**WEST SUSSEX COUNTY COUNCIL
FLOOD RISK MANAGEMENT CONSULTATION**

DATE: 20th June 2017

SUBJECT: BE/63/17/OUT

LOCATION: The Cottage, Shripney Road, Bognor Regis, West Sussex, PO22 9PA

Figure 5-2 – Potential Locations of Permeable Paving (not to scale)

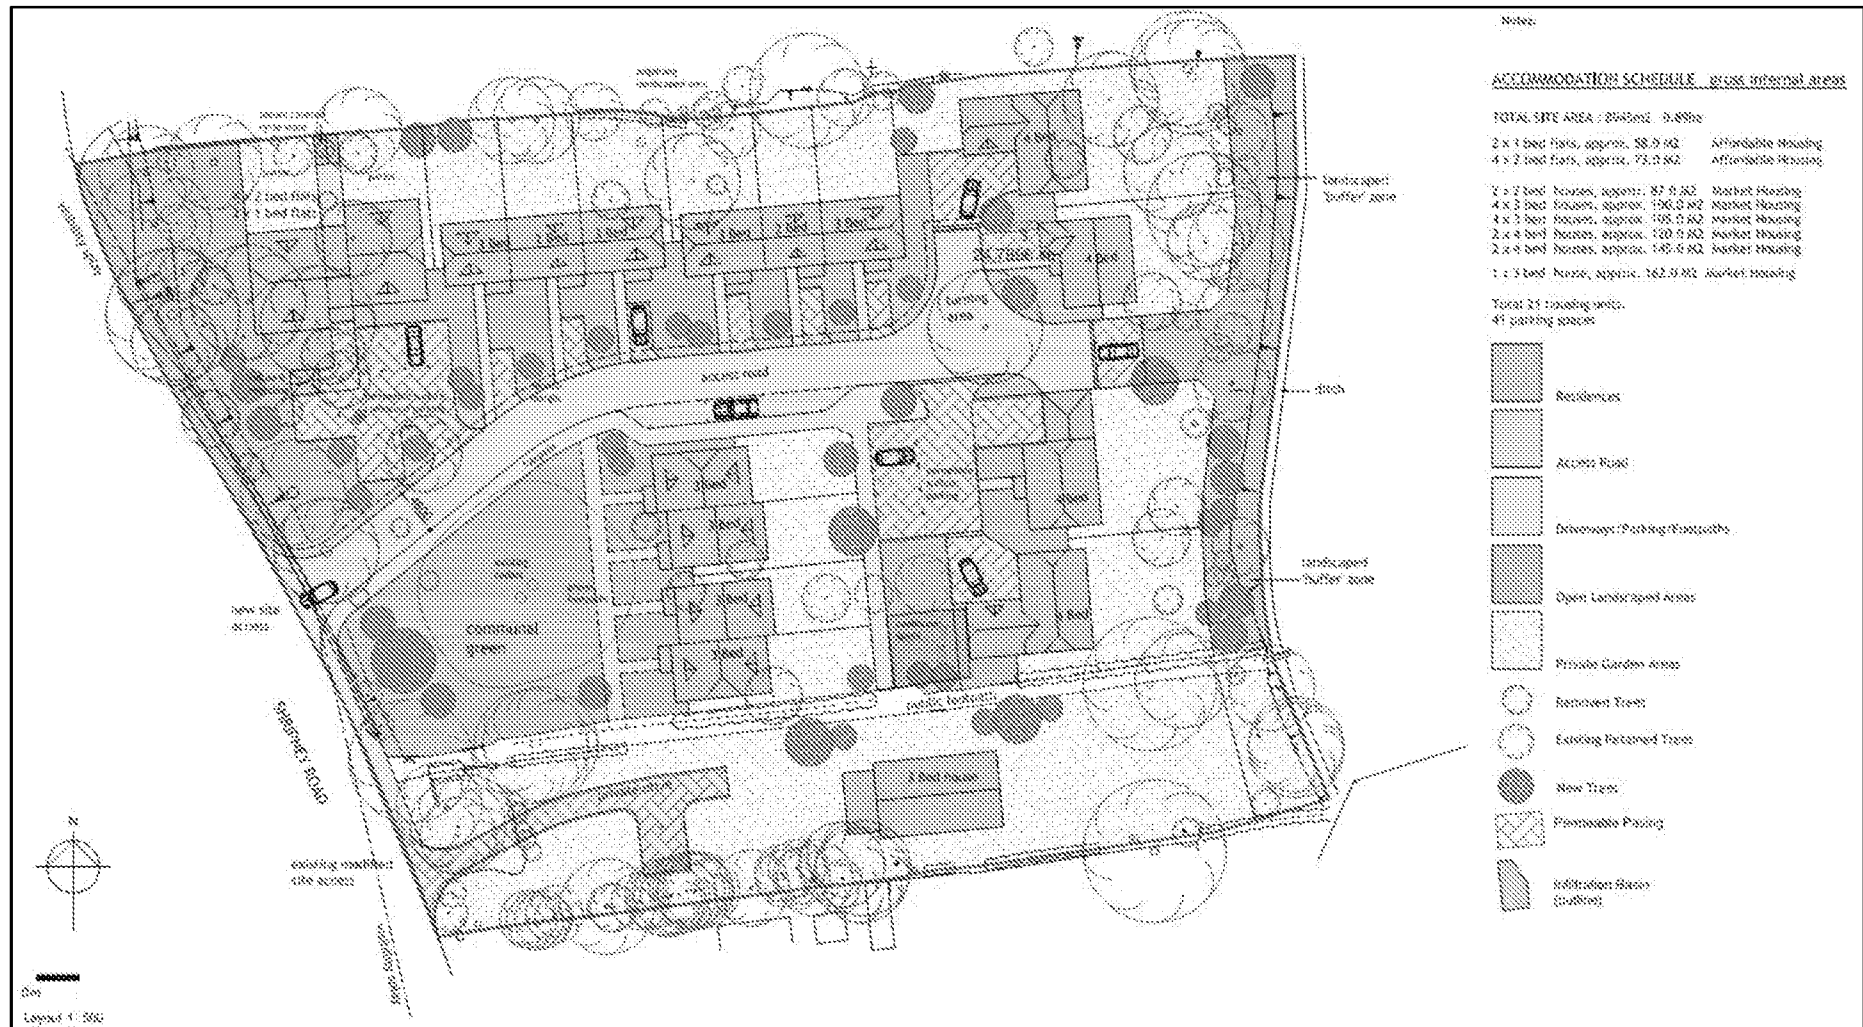
The FRA included with this outline application proposes that infiltration basin/permeable paving will be used to restrict the runoff from the development to Greenfield run-off rates. Once all forms of infiltration have been fully investigated this method would, in principle, meet the requirements of the NPPF, PPG and associated guidance documents.

Development should not commence until finalised detailed surface water drainage designs and calculations for the site, based on sustainable drainage principles, for the development have been submitted to and approved in writing by the Local Planning Authority. The drainage designs should demonstrate that the surface water runoff generated up to and including the 1 in 100 year, plus climate change, critical storm will not exceed the run-off from the current site following the corresponding rainfall event.
